DECISION DELEGATED TO HEAD OF PLANNING

Application No: H15-0834-25 **Applicant:** Clarke Group Construction Ltd

Proposal: Erection of 7 detached dwellings - outline approval H15-0360-22 - Approved under H15-0865-24. Replacement of stone window & door heads for 215mm brick soldier courses

Location: Land Adjacent To 62 Water Gate Quadring Spalding

Drawing
Single Garage
1:50 @ A2

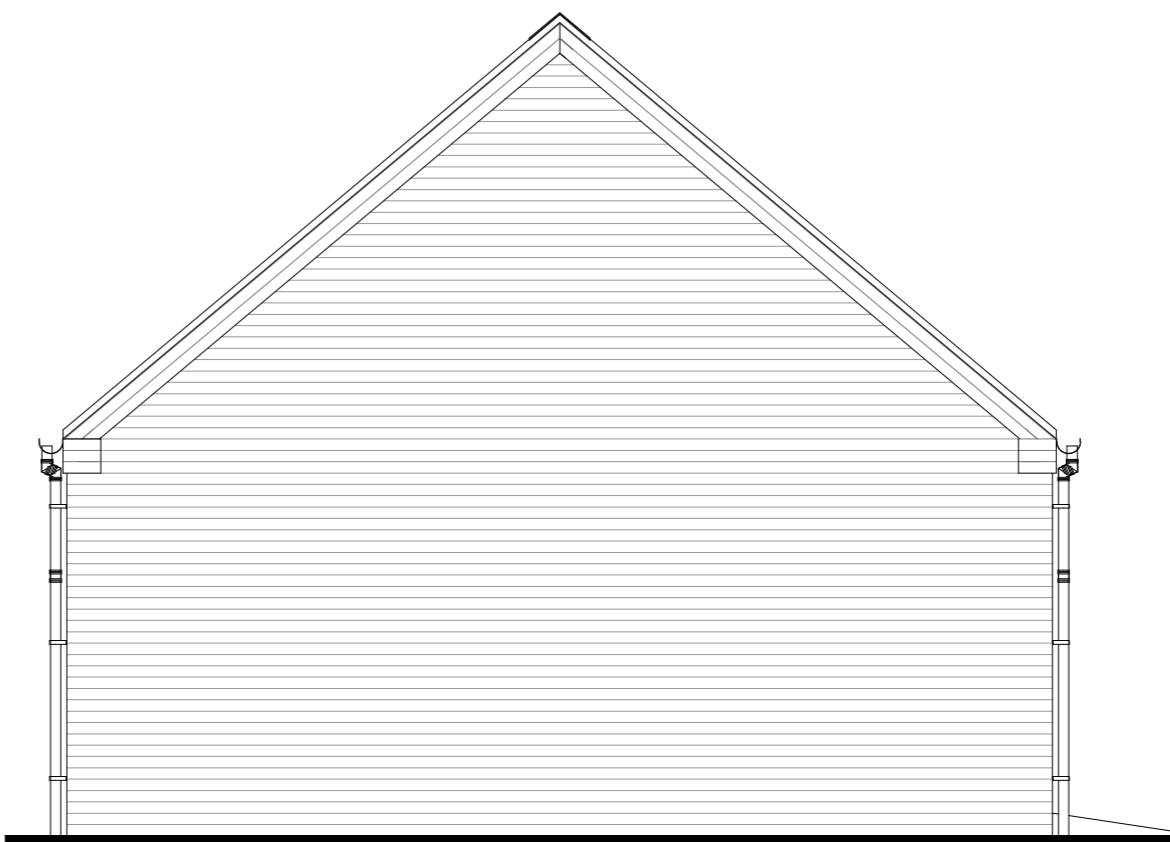
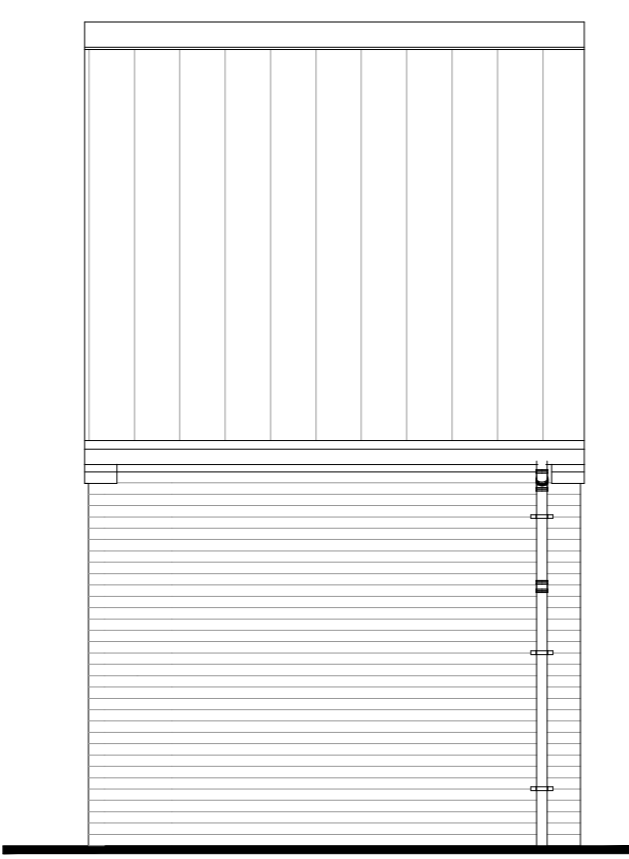
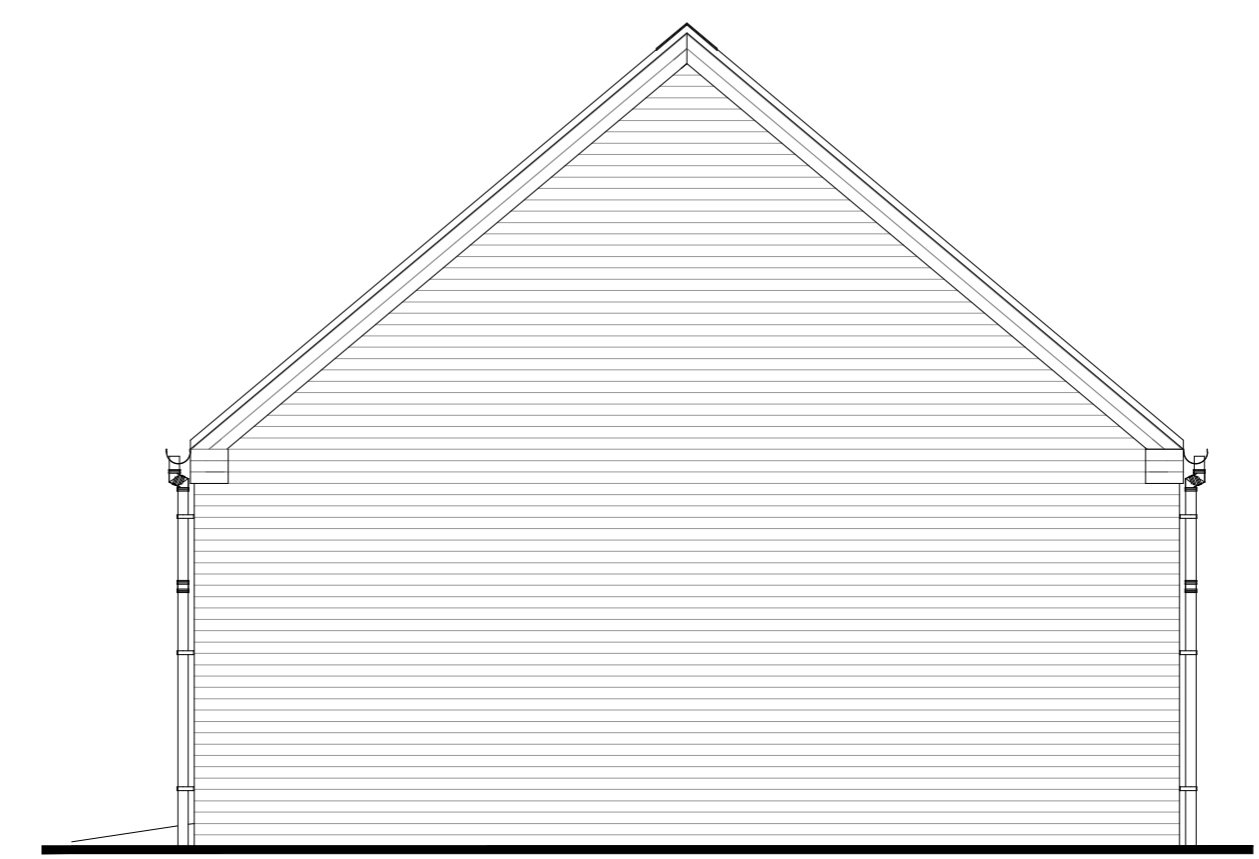
The principle of development has already been found to be acceptable through the approval of permission H15-0865-24. The application seeks to amend the approved plans by replacing the stone window and door heads with 215mm brick soldier courses. Brick soldier course detailing is proposed on the three consented house types and the detached garages. The visual impact of the brick soldier course detailing is acceptable and non-material.
